CITY OF ALBUQUERQUE

February 14, 2017

**Re: Paradise View Universal Apartments
Erosion and Sediment Control Plan
Engineer's Stamp Date 2-5-17 (B11E010)**

ENGINEER'S SEAL 	PARADISE VIEW UNIVERSAL APARTMENTS	
	EROSION CONTROL PLAN	
	 Rio Grande Engineering 1606 CENTRAL AVENUE SUITE 201 ALBUQUERQUE, NM 87106 (505) 872-0989	SHEET # 4
2/5/17		JOB # 21641

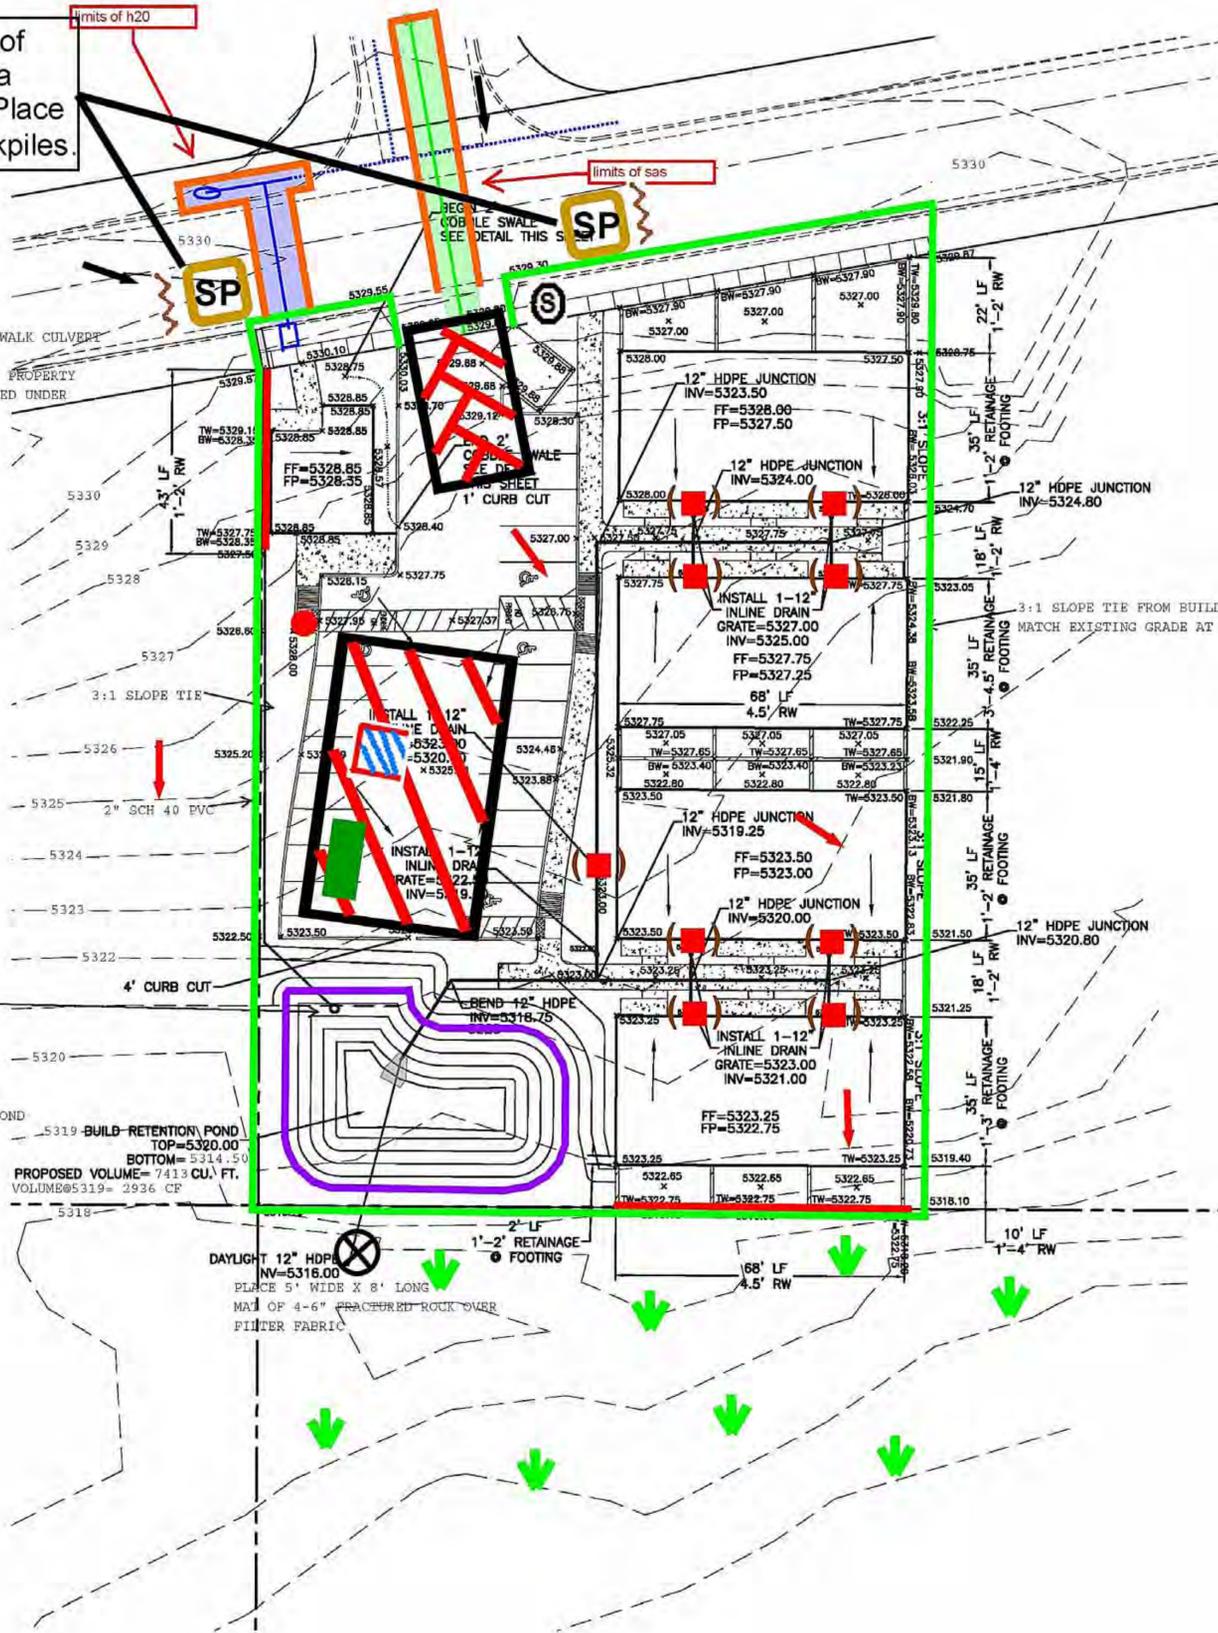
1. The plan does not have a legend for the BMPs.
2. Proposed grades on the western, eastern and southern boundaries are higher than existing grades so sediment BMP is required on these boundaries.
